My reference: 3/2024/1018
Direct Dial: (01200) 425111
www.ribblevalley.gov.uk
Email: planning@ribblevalley.gov.uk
Date: 13 February 2025

Location: Talbot Hotel 5 Talbot Street Chipping PR3 2QE
Proposal: Approval of details reserved by conditions 4 (door and window details) and 12 (boundary treatment) of listed building consent 3/2023/0086.

6521 -D0C5

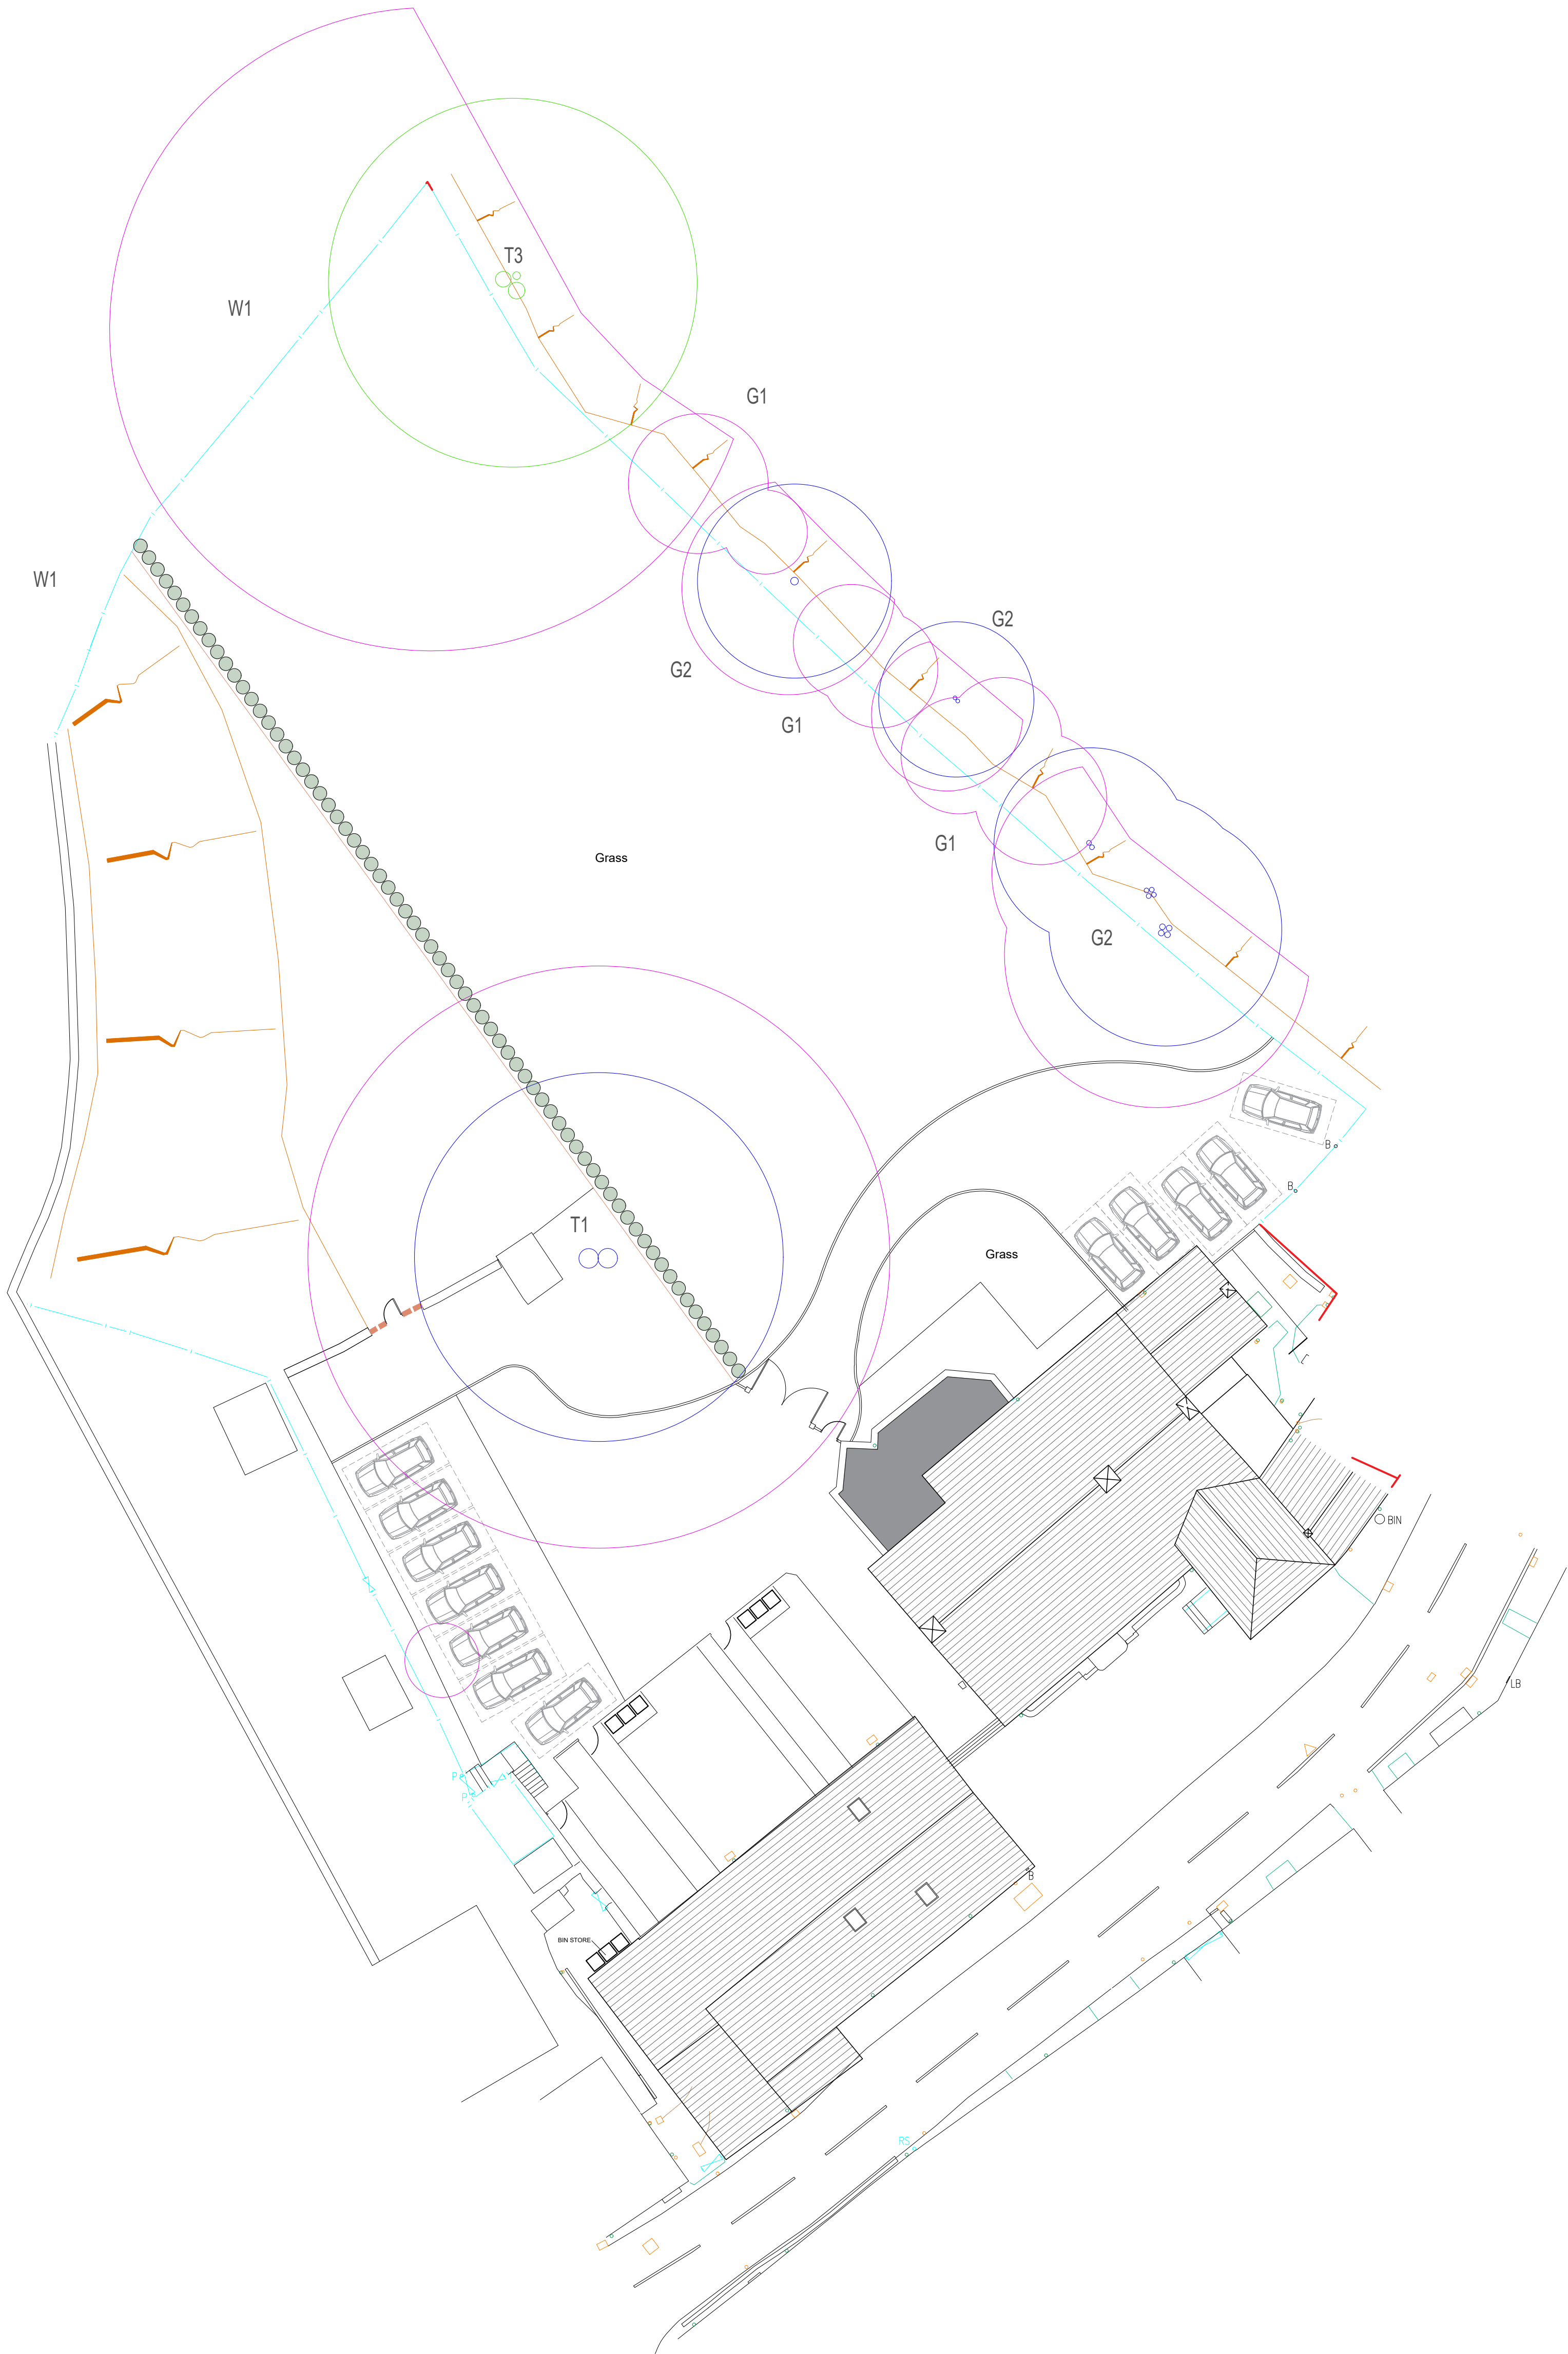
Condition 12 (Boundary Treatment) can be partially discharged in so far as the details shown on Proposed Site Plan 6521-DOC5 dated November 24 for the vehicle/pedestrian gates and fencing and laurel hedge planting are acceptable. The development shall be carried out in strict accordance with details hereby approved.

The Cherry Laurel to be planted within the Root Protection Area (RPA) of T1 Sycamore tree must be planted at distances which fully take account of the tree roots of the existing Sycamore tree in order to ensure that no root loss occurs that would undermine the life expectancy of the tree and excavated by land as per approved Arboricultural Impact Assessment dated March 2022.
